Application for a Non-Material Amendment Following a Grant of Planning Permission

Demolition of existing barn (building 2) and erection of dwelling.

H19-0783-22

Please see attached drawing: 2024-12 BR1 Proposed floor plan and elevations REV C.

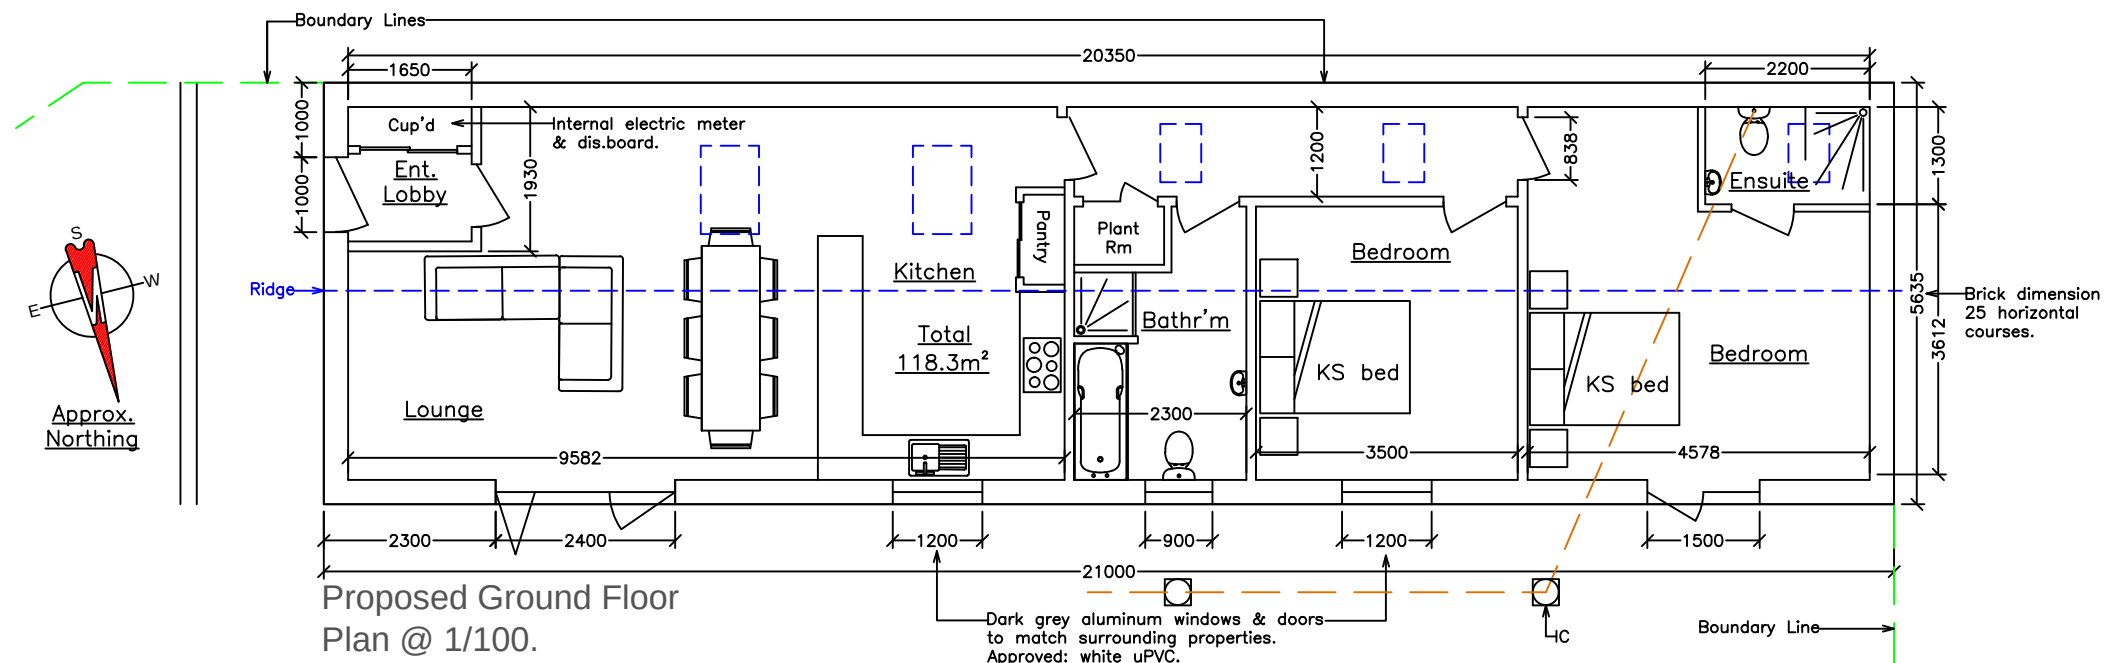
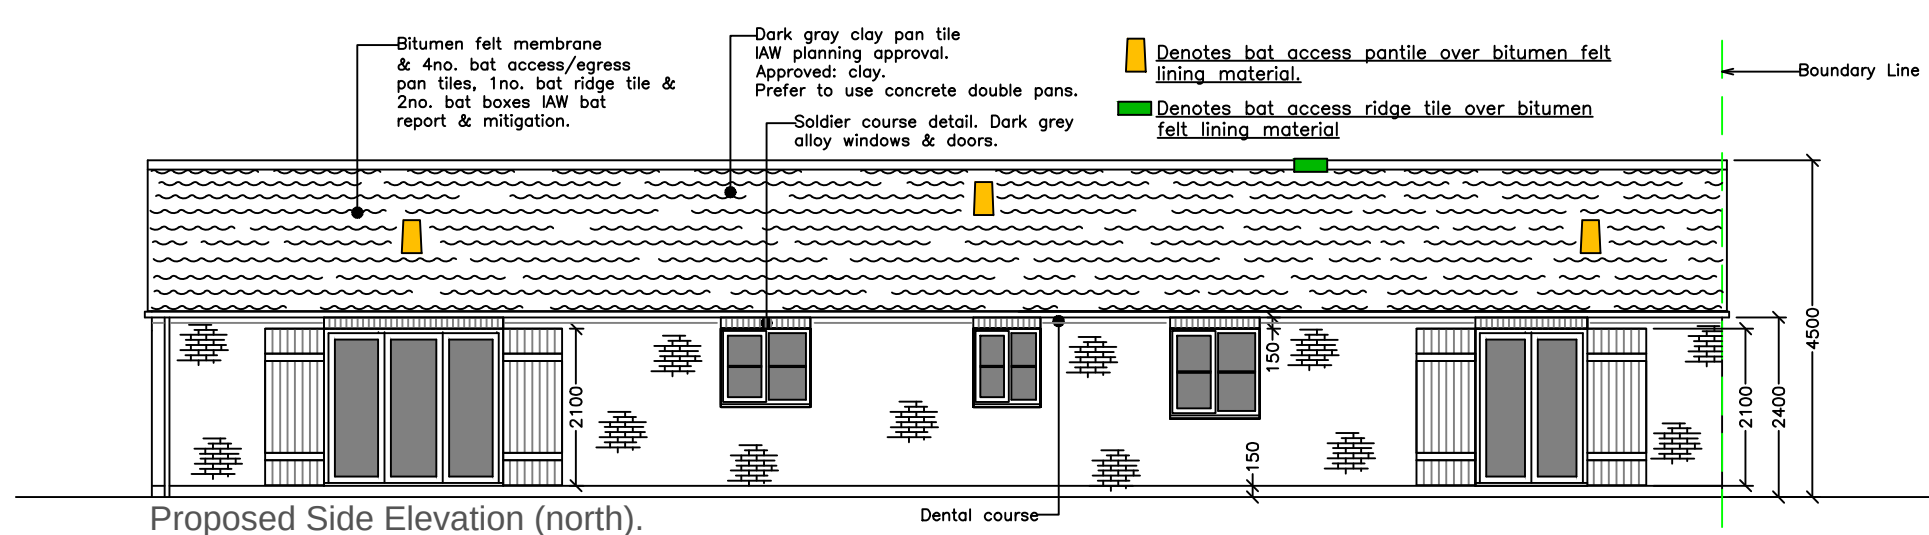
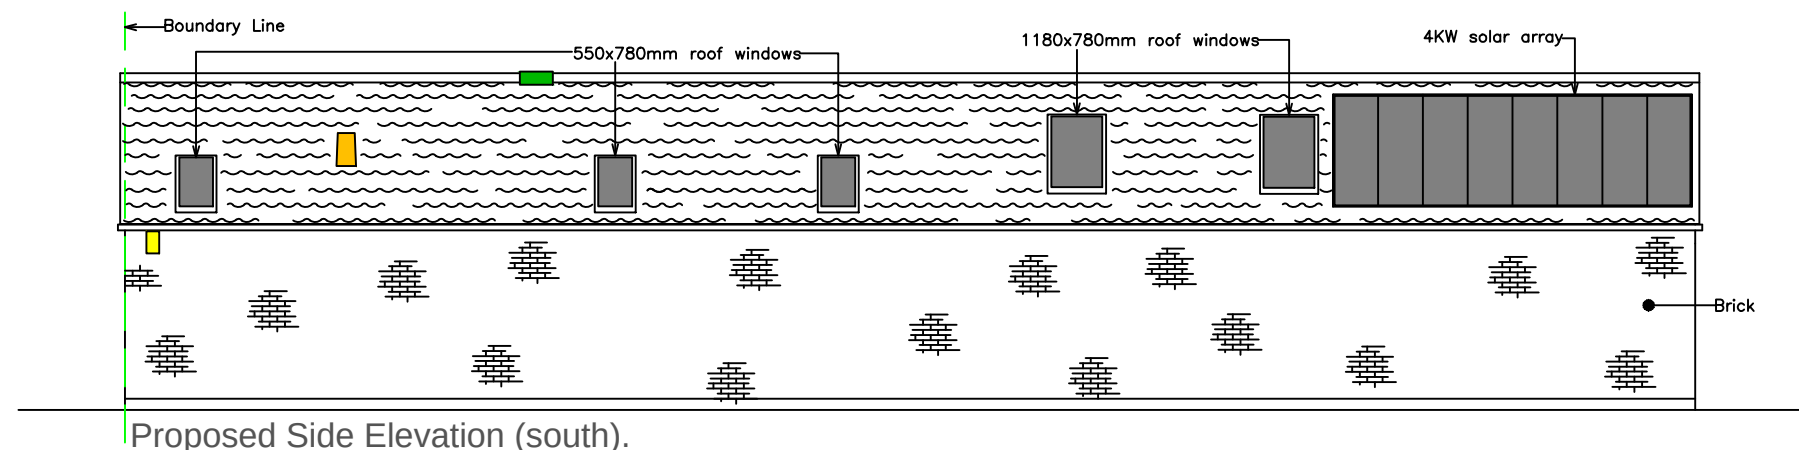
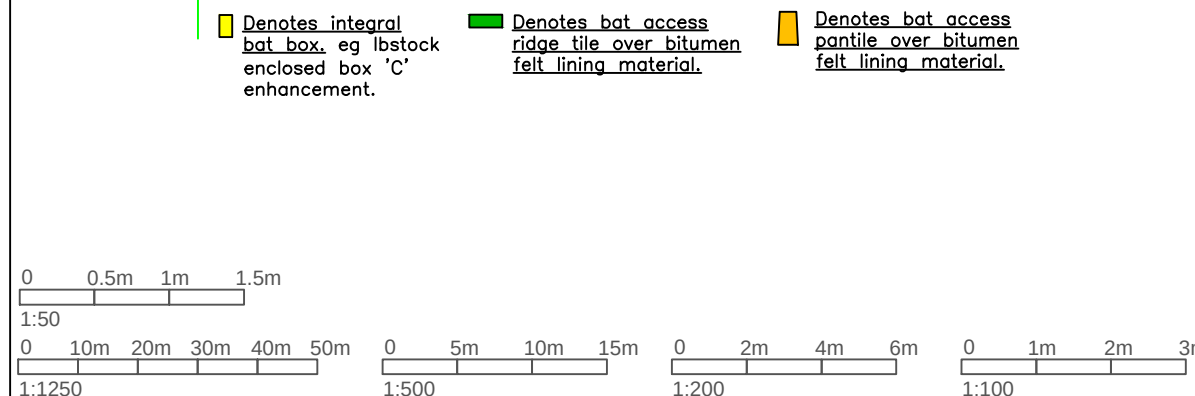
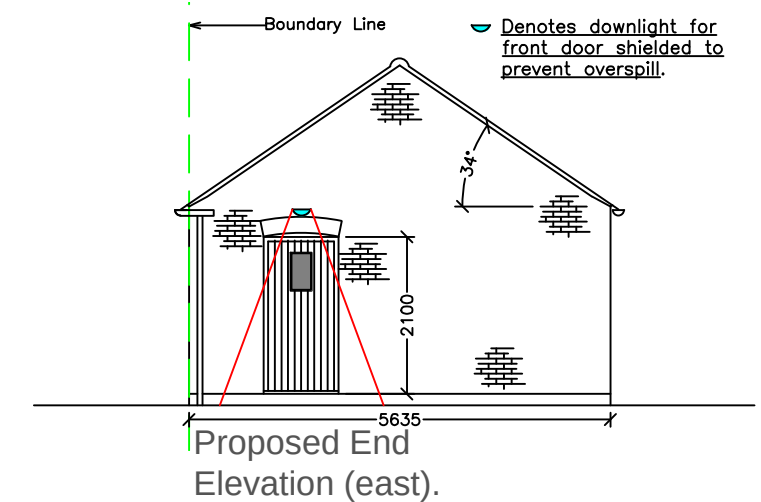
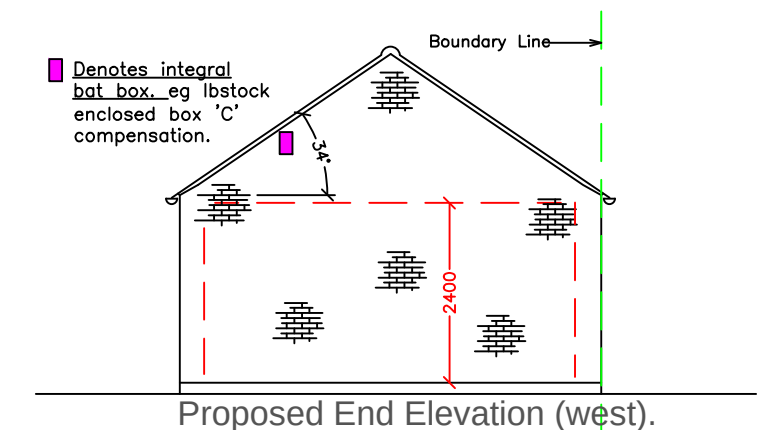
Roof Tiles: From the approved (clay pan tiles) to 'Sandtoft' double pan tiles smooth dark grey. Other properties in the immediate vicinity have dark roof coverings.

Windows & Doors: From the approved (white uPVC) to dark grey aluminium as per other properties in the immediate area.
